From: [Holly Erdman](#)
To: [Jeremiah Cromie](#)
Cc: [Jesse Cox](#)
Subject: RE: SE-22-00054 Casto - Notice of Application
Date: Friday, June 3, 2022 10:32:40 AM

SUBJECT: SE-22-00054 Casto

Public Works SEPA Application Comments:

**BOUNDARY AND TOPOGRAPHIC SURVEY**

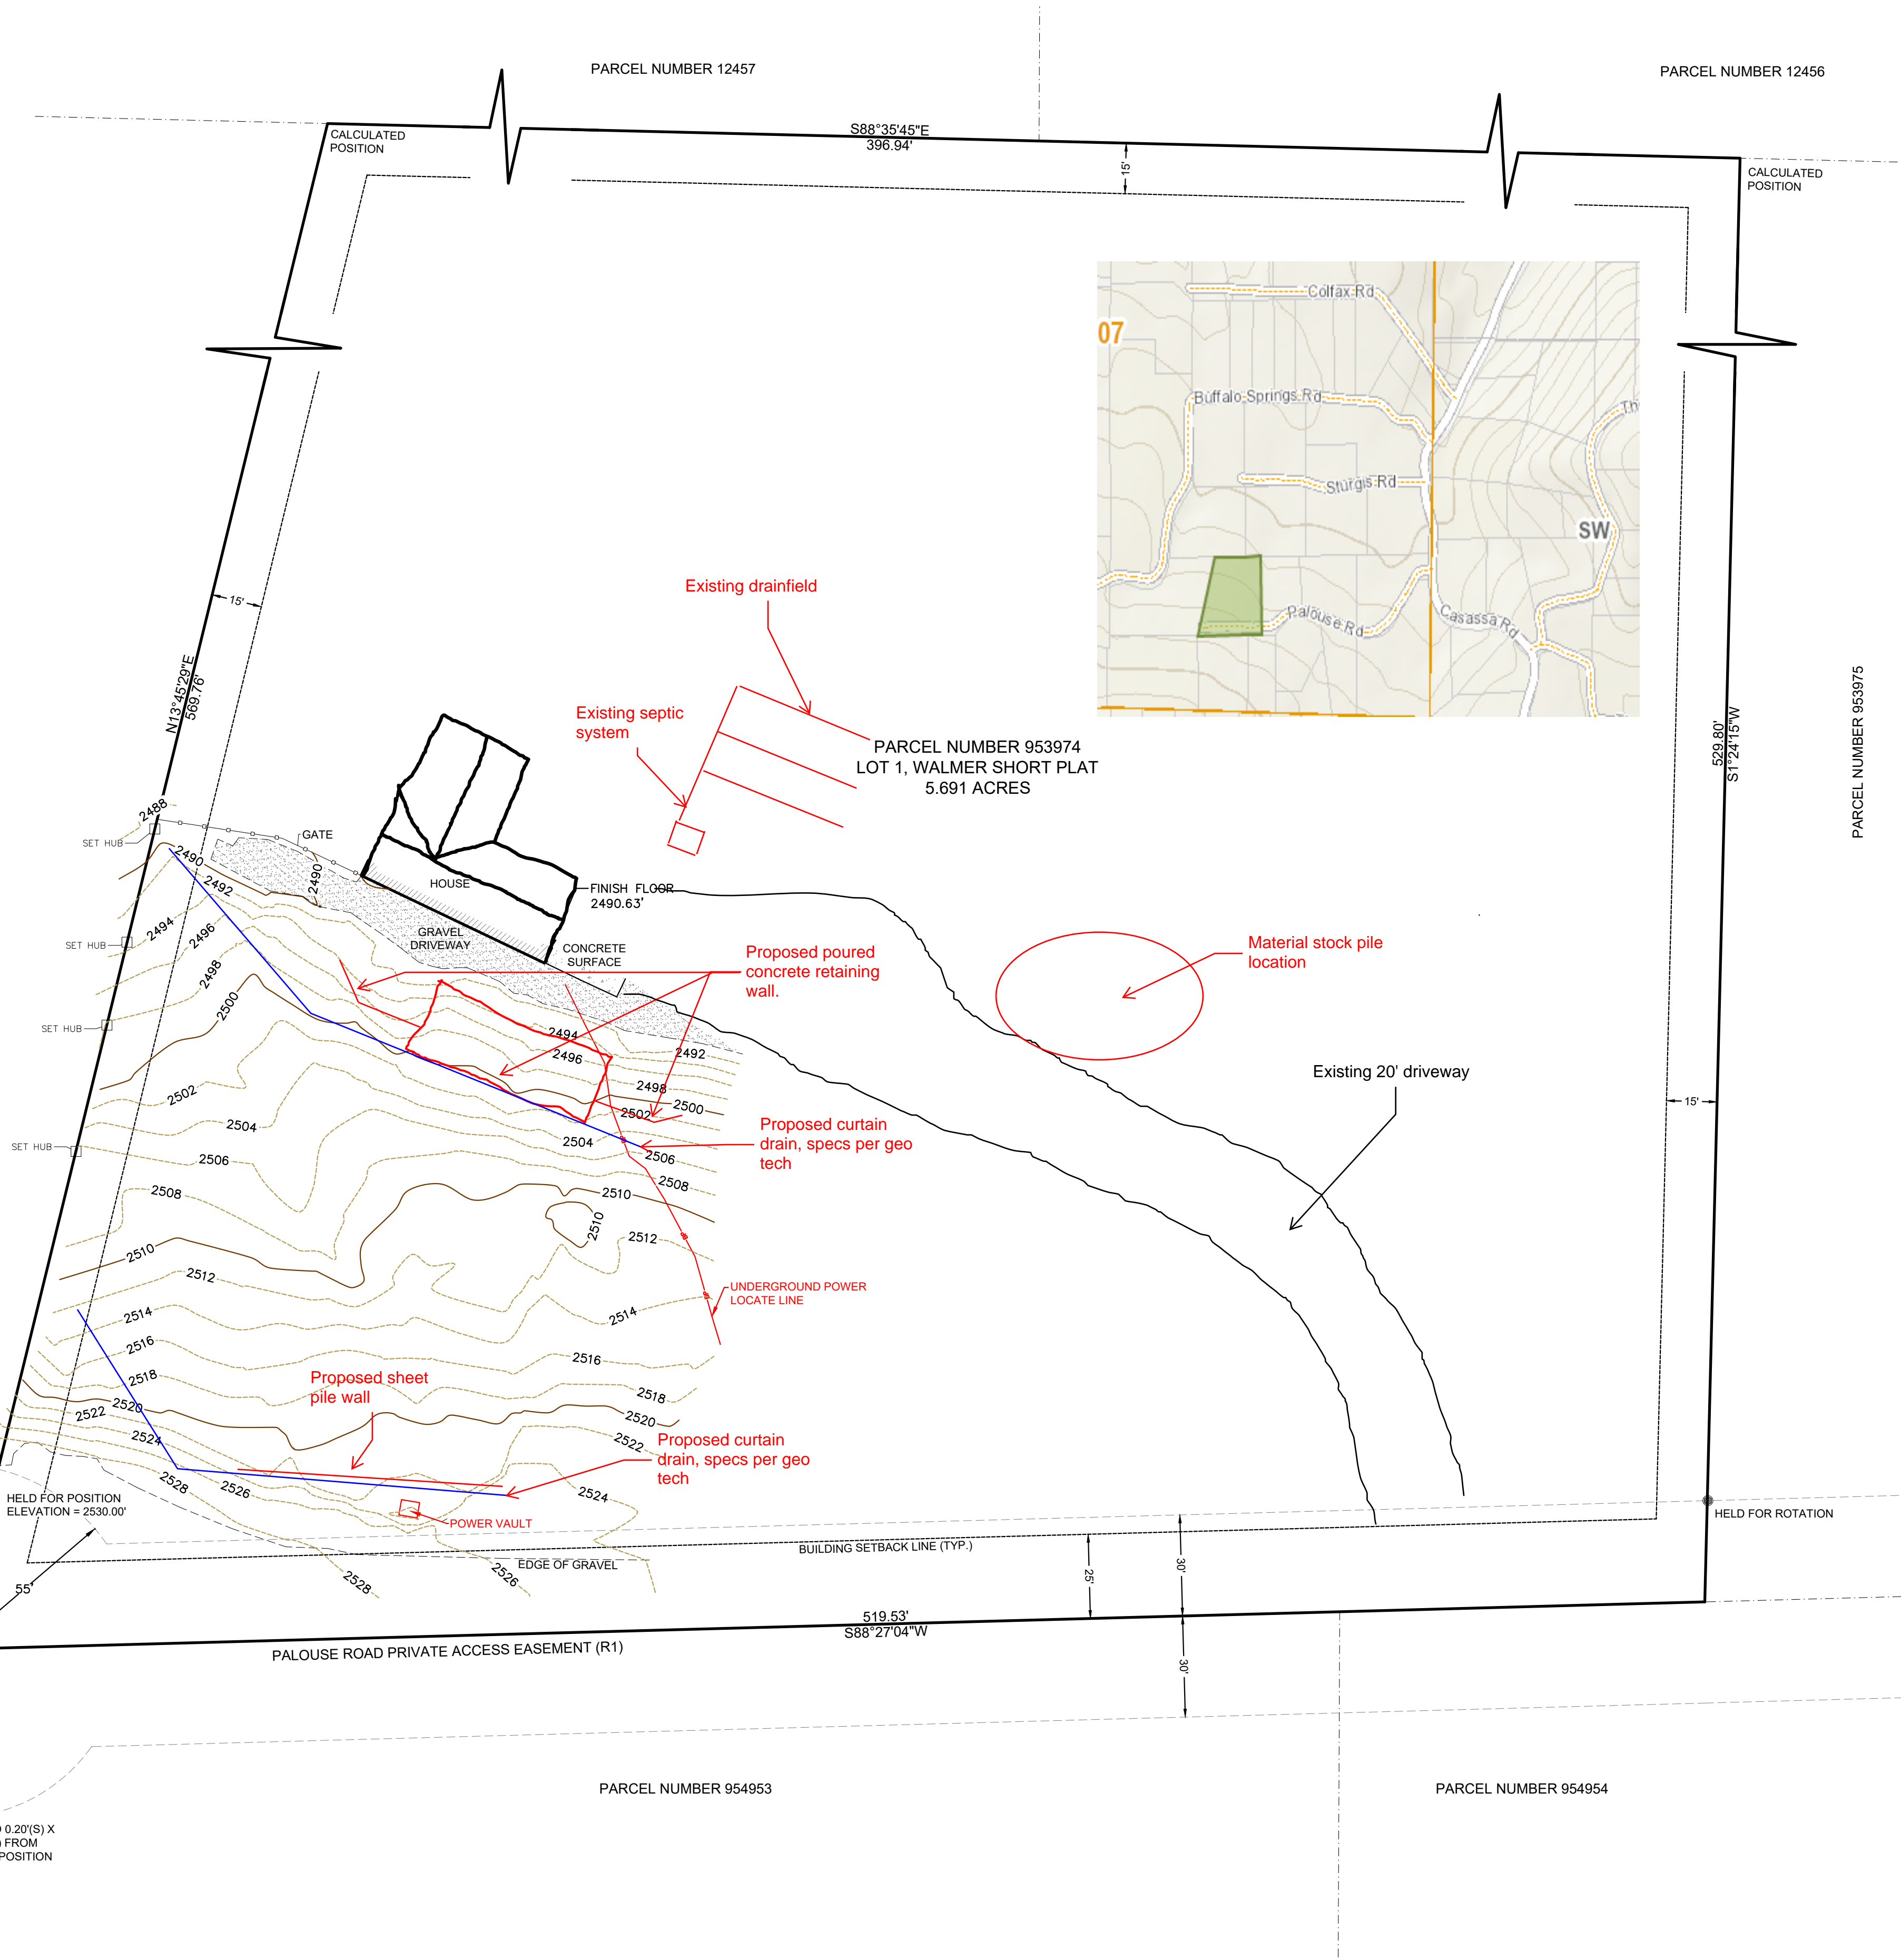
- 1. In the application documents, the applicant appears to have revised the work of a Licensed Land Surveyor, presumably without permission. Public Works recommends delaying any approval of this SEPA application until such time the submitted materials are revised to meet the requirements of WAC 196 or Public Works receives confirmation from the Licensed Land Surveyor that the submitted site map is his work.***

Sheet Contents
Site Plan
Project
Casto Sheet Pile Wall (Cle Elum)
561 Palouse Road
Cle Elum, WA 98922
Casto, Devin

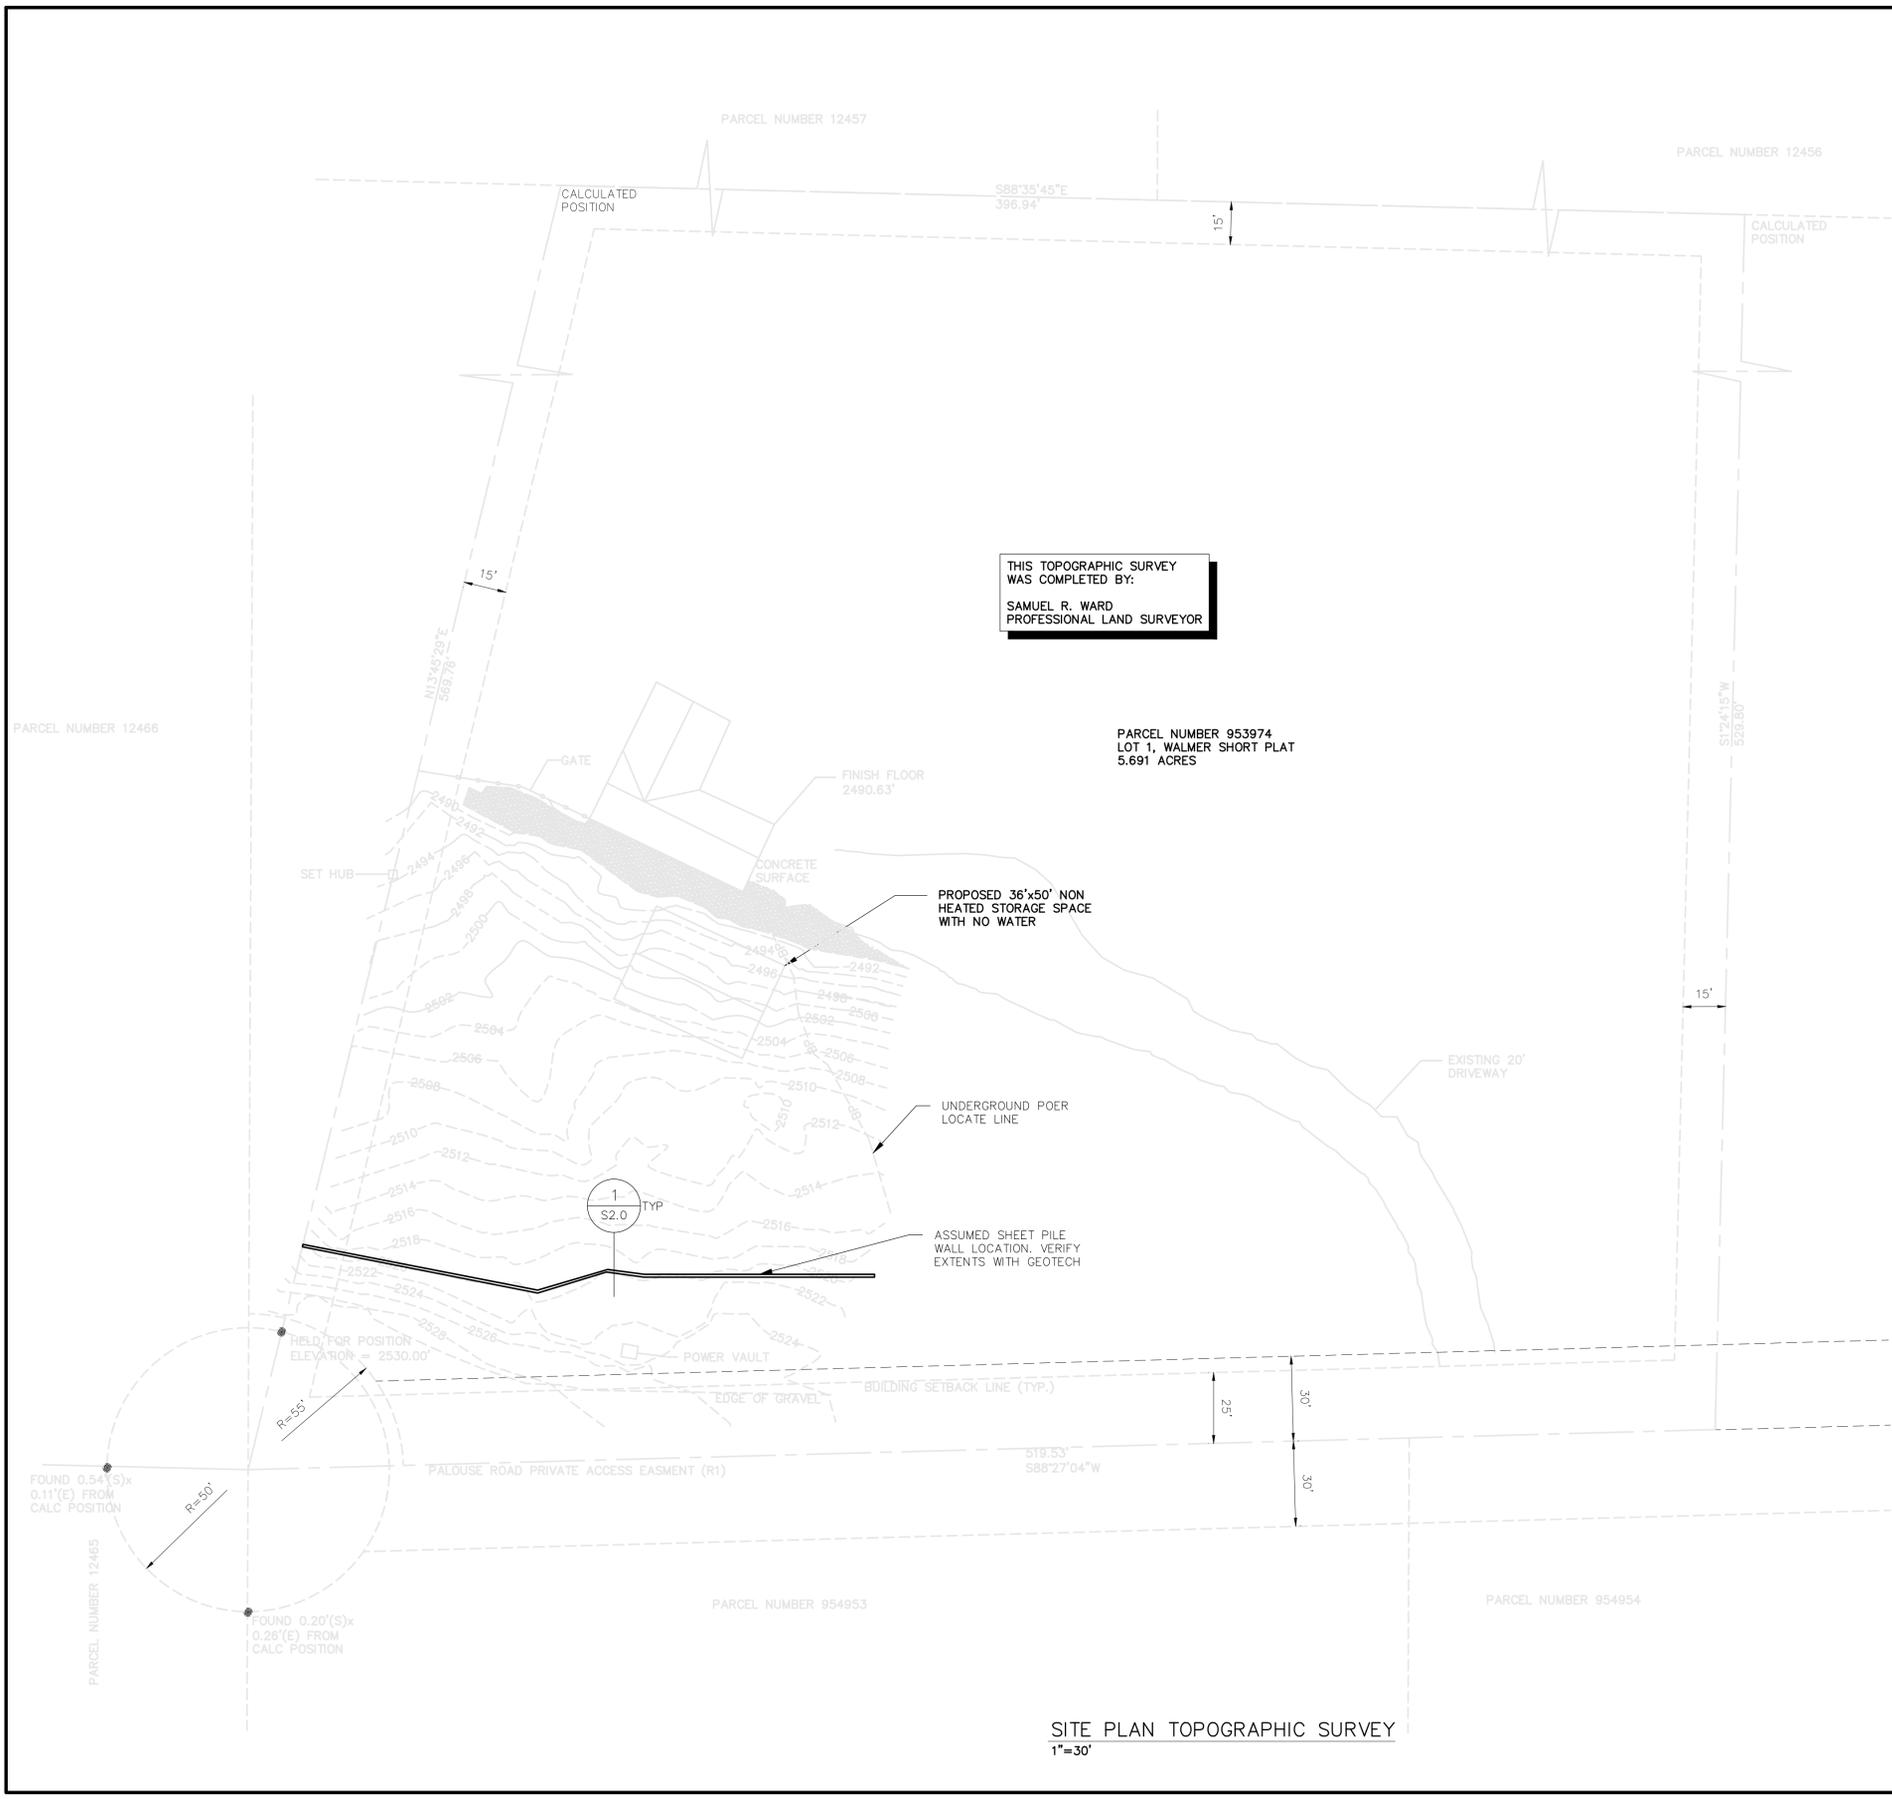
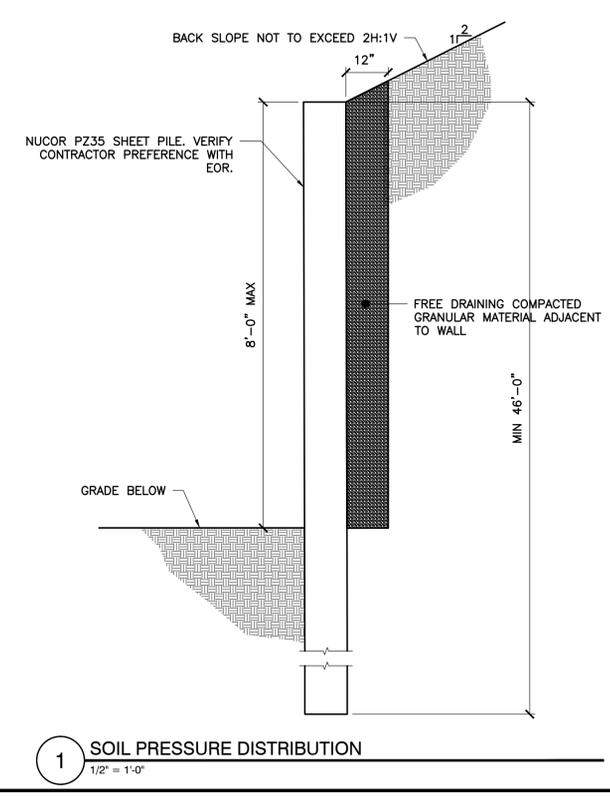
I had an excavation company for 17 years and moved a lot of dirt and worked on a couple sites on the west side with sheet pile walls operating an excavator and hoe pack for the contractor. I have never heard of a "temporary sheet pile wall, and no analysis and design of bracing, temporary or permanent, requested or conducted. All bracing, temporary and permanent, shall be the responsibility of contractor." Who is the contractor and are they certified/licensed to do this type of work ???
